Phone: 0300 123 6780
Email: developeras@lancashire.gov.uk
Your ref: 3/2026/0153
Our ref: 3/2026/0153/HDC/KW
Date: 18 June 2026

Location: Land off B6478 Wigglesworth Road Slaidburn
Proposal: Formation of a stone access track and improvements to an existing access.
Grid Ref: 371520 452238

Proposed Access Plan
Scale 1:200 @ A3

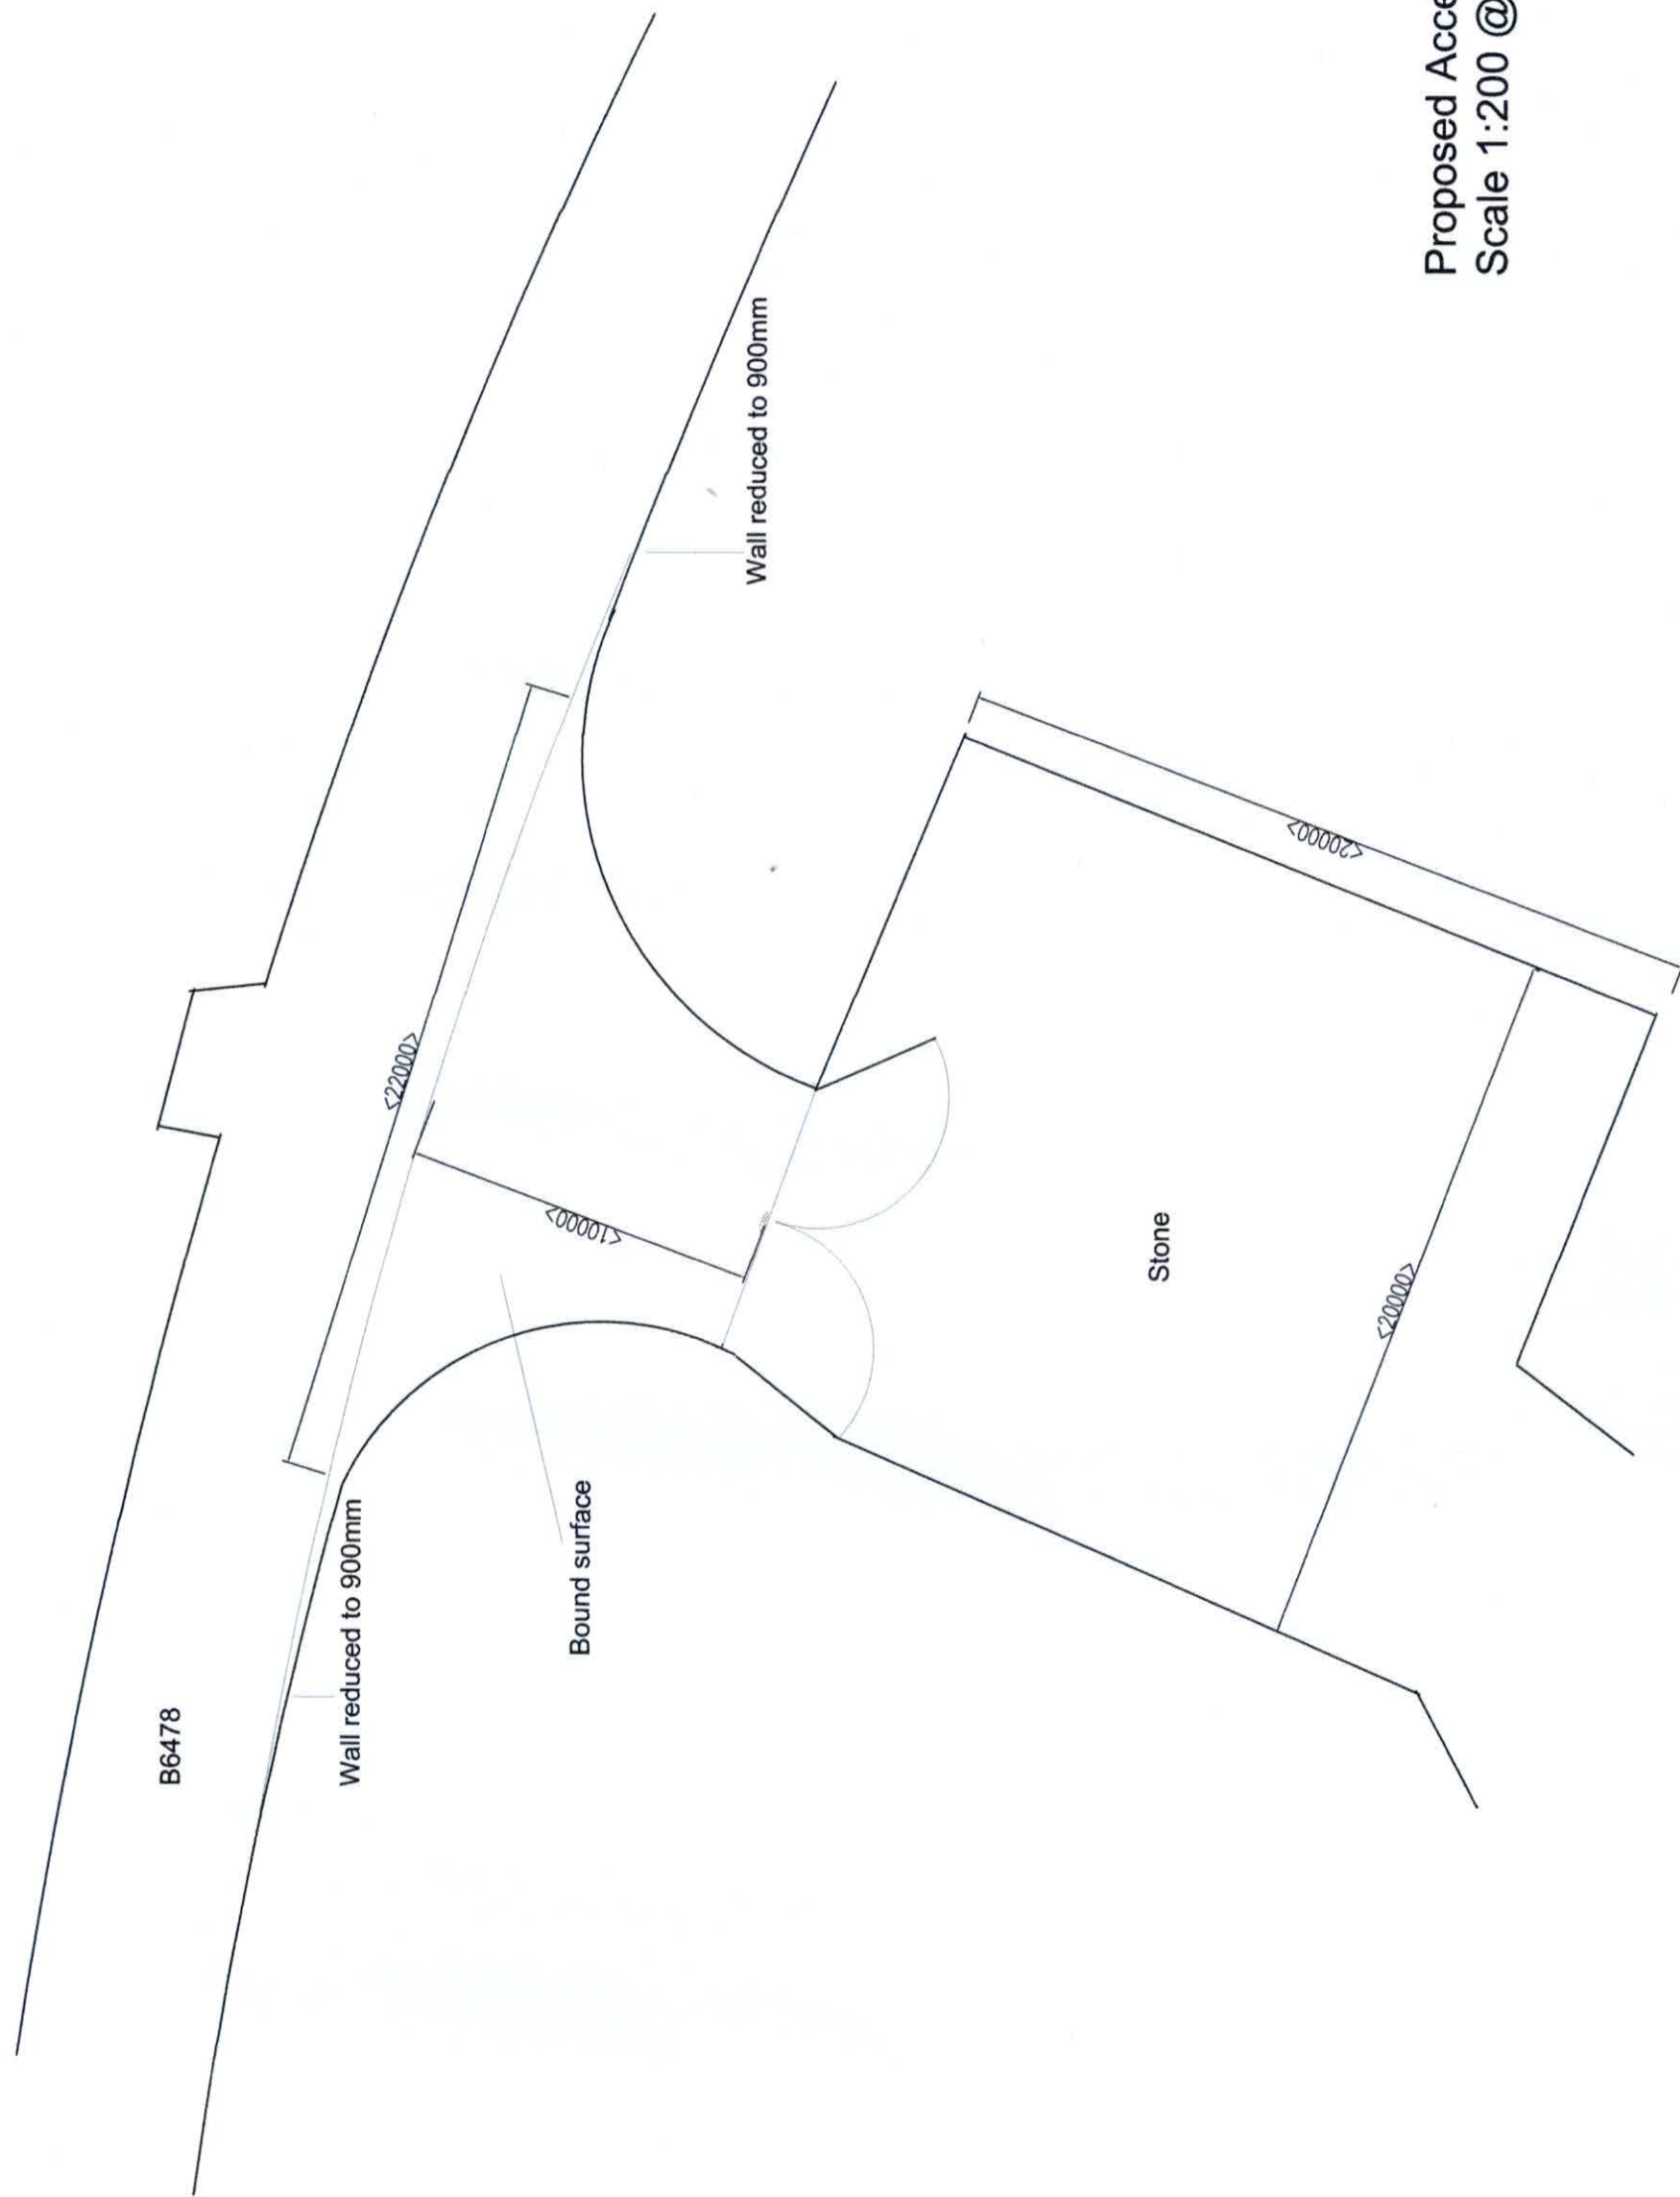
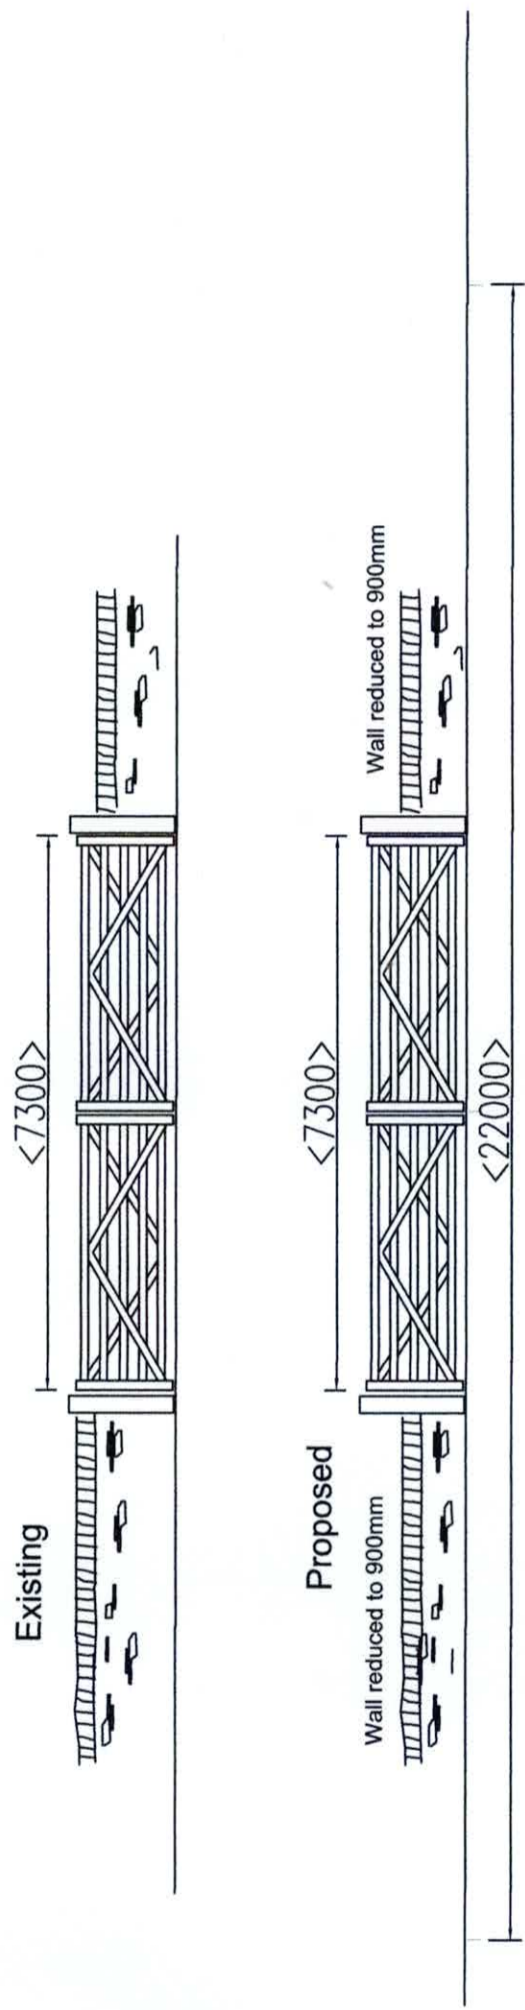
The amendments to the existing access will result in the access gates retaining the width of 7.3m, however they are proposed to be set back 10m from the carriageway edge, allowing for the gates to be operated with an agricultural vehicle stopped within the access, removing conflict from the carriageway.

The access from the carriageway will also be widened and feature a radius providing smoother turning into and out of the site as well as reducing the risk of overrunning. The widening of the existing access at the carriageway edge will need to be undertaken as part of a Section 278 agreement with Lancashire County Council.

The first 10m into the site shall be appropriately paved in tarmacadam, concrete, block pavements, or other hard material to prevent loose surface material from being transferred onto the adopted highway. The applicant also puts forward visibility splay improvement with the boundary walls proposed to be reduced to 900mm, allowing for a 100m sight line to the west and 200m to the east.

Proposed Site Plan  
Scale 1:2000 @ A3

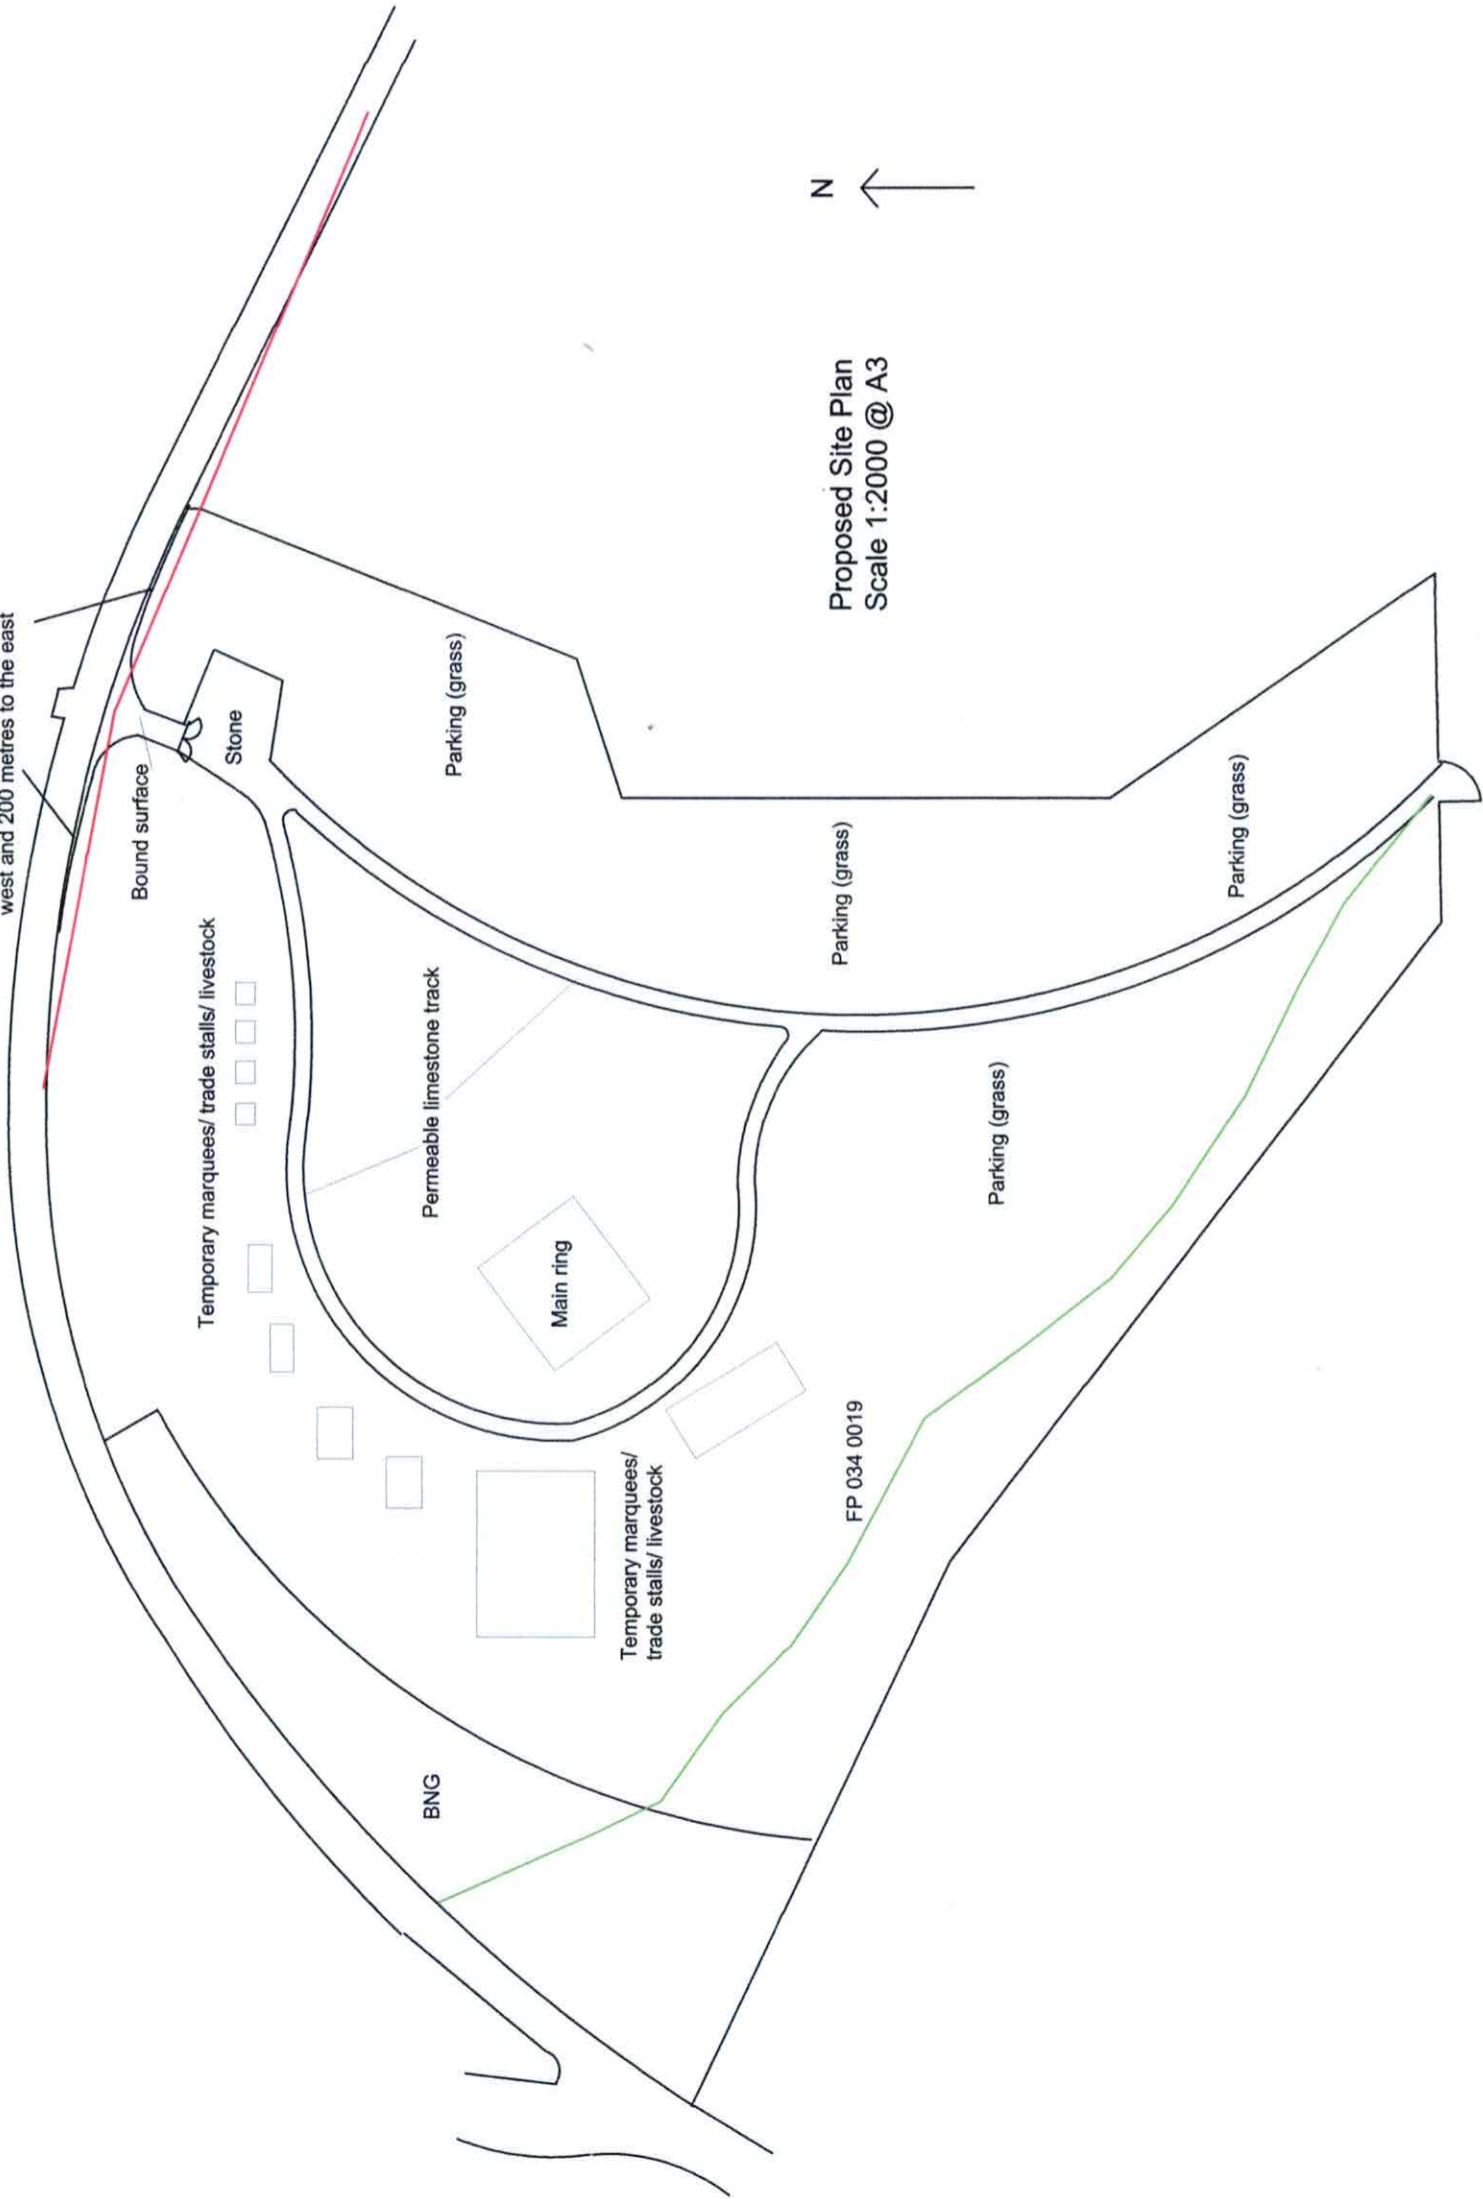
As such, visibility splays in both directions should be 2.4m back extending for 120m in line with recorded traffic speeds. It is understood at this time that updated visibility splays has not been provided.

The proposed site plan shows that 100m to the West of the access and approximately 172m can be achieved to the East of the access. This presents a short fall of 20m to the West, and as such, the LHA would request that the applicant undertake a further visibility assessment following the ATC to consider if an improved splay can be achieved in this direction.

In conclusion, following the ATC the applicant is requested to re-evaluate the visibility to the West of the access and provide a clear, detailed visibility splay of 2.4m back from the carriageway edge extending 120m in both directions. Any obstructions within the visibility splay, such as walls or vegetation, will need to be reduced to 0.9m above the carriageway level.
